Consultee Response 2

Change of use application from C3 dwellinghouse to C2
Residential Care Home and Regularisation of Outbuilding 2

Mistyfield House

- **Applicant:** Jaiswal Property Developments Ltd
- **Agent:** Architectural Vision Ltd
- **Consultee Response 2:** Response to Comments Raised by Sarah Sharp, Highways Development Control.
- **Prepared by:** Architectural Vision Ltd on behalf of the Applicant.
- **Date:** August 2nd 2026
- **Document Reference:** GNH1-AVL-01-XXX-DA-A-012-P01

Dwg No. Rev
GNH1-AVL-05-00G-DR-A-001 P02

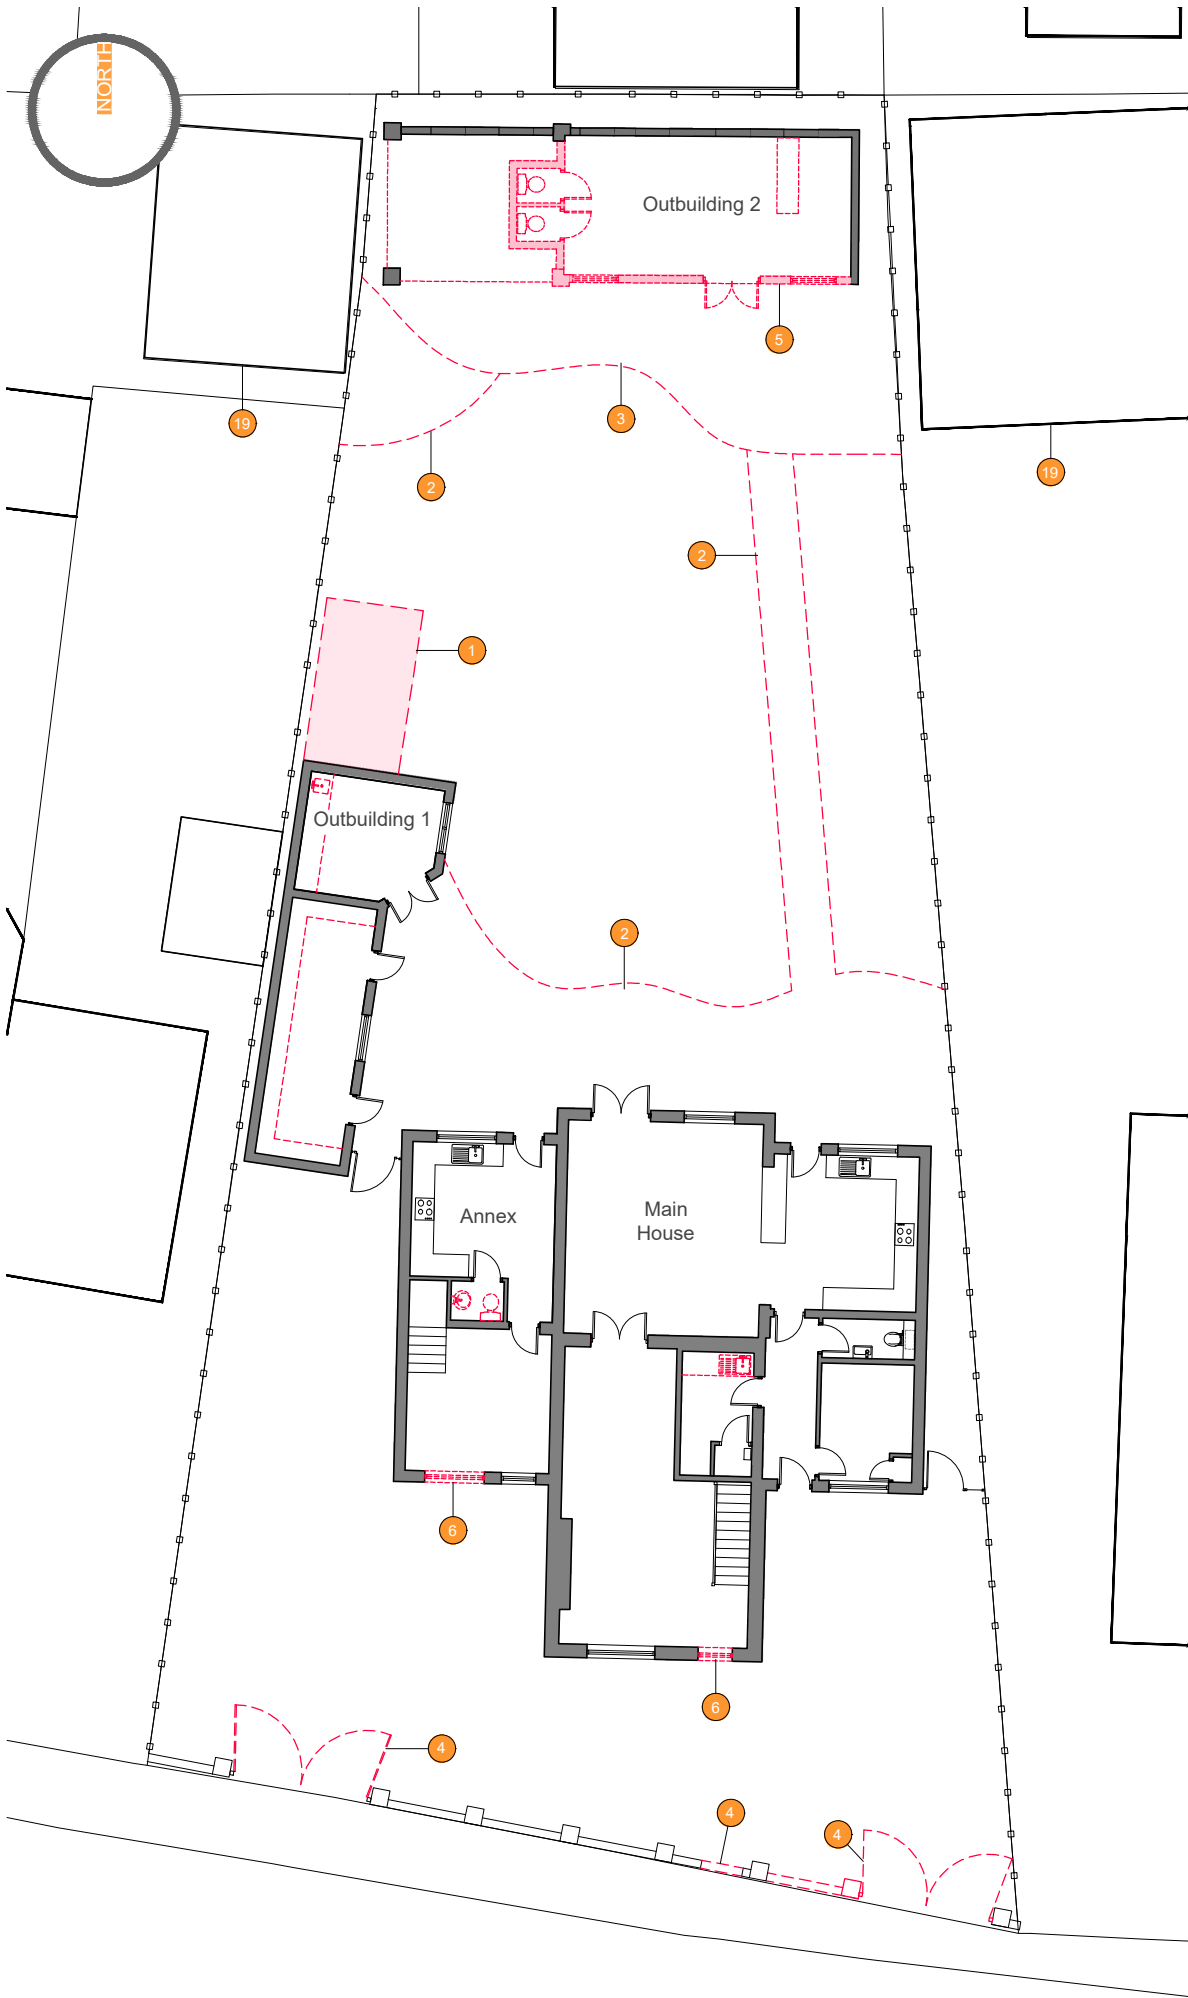
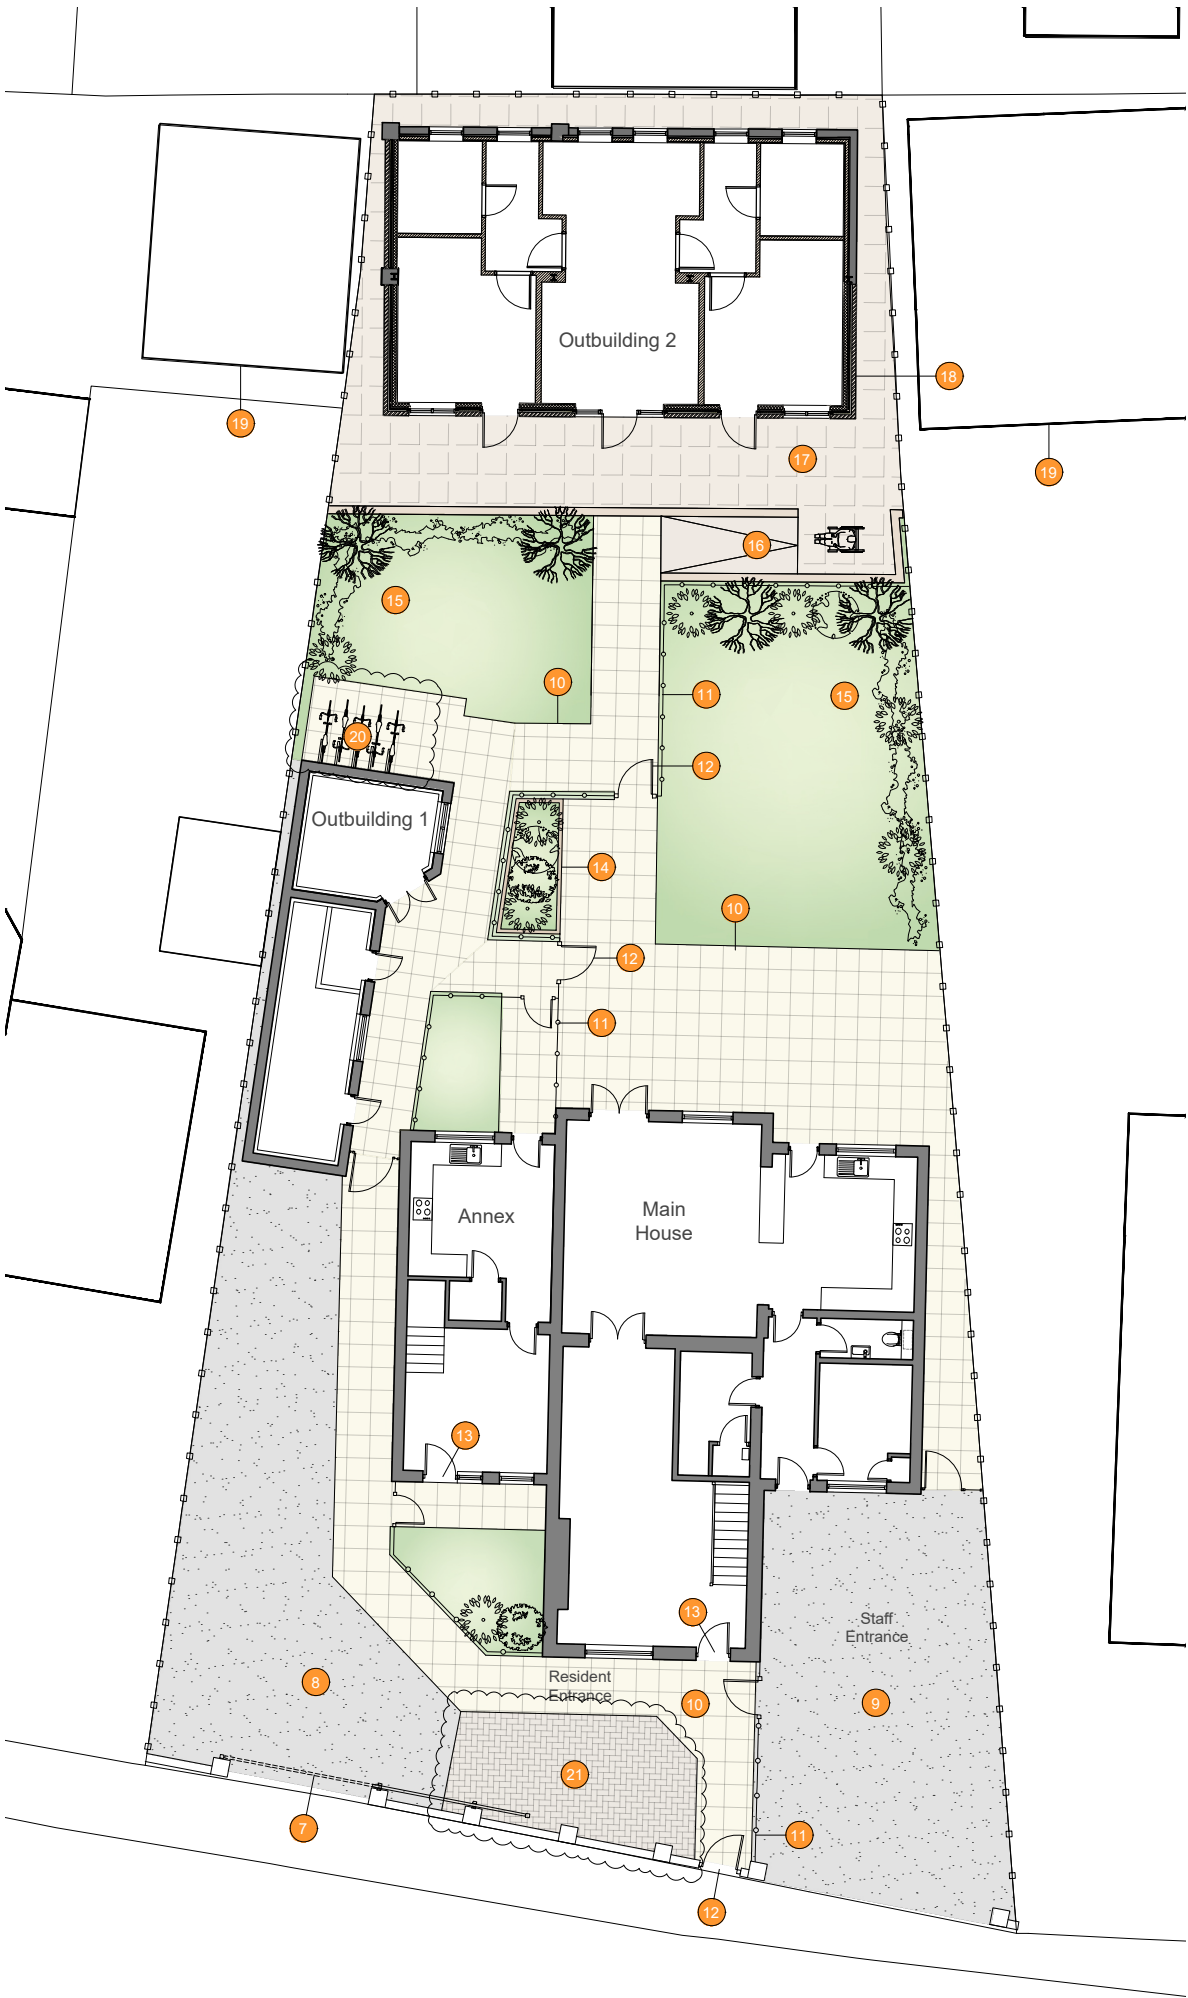
This response has been prepared on behalf of the applicant to address the comments raised by Highways Development Control in their consultation reply dated 20th July 2026. It provides the additional operational detail requested in relation to staffing levels, shift arrangements, parking demand, visitor management, resident transport and vehicle manoeuvring, and is supported by a suite of revised drawings that demonstrate how the site can accommodate the proposed use safely and without material impact on the local highway network.

The operator is actively recruiting within the local area and will encourage applications from people who are able to walk, cycle or travel by public transport. A formal Cycle to Work scheme will be operated and secure cycle storage is proposed within the rear garden which is shown on the updated Site Plan.

- Two staff vehicles will park on the eastern driveway adjacent to the primary staff entrance.
- The third (and occasional fourth) staff vehicle will park on the western driveway.

- Eight usable parking spaces within the site curtilage. (Spaces 1-4)
- The wheelchair-accessible pool vehicle (Space 2) normally parked in a staff space, with the ability to move into the accessible bay when required for loading/unloading or if a fourth staff vehicle is present.
- A designated accessible parking bay (Space 3) on the western driveway kept available for visiting wheelchair users.
- A clear practical separation between the eastern driveway (primarily for staff) and the western driveway (primarily for resident and visitor use).

The designated accessible bay will be clearly signed and provided with a firm, level block-paved surface suitable for wheelchair users. Because staff parking demand is expected to be only three to four vehicles under normal operating conditions, and because all non-essential visits are programmed outside the two daily handover periods, the eight spaces provide a comfortable margin. The layout has been designed so that staff vehicles, the pool car and occasional visitor or delivery vehicles can all be accommodated without conflict or overspill onto Church Hill.
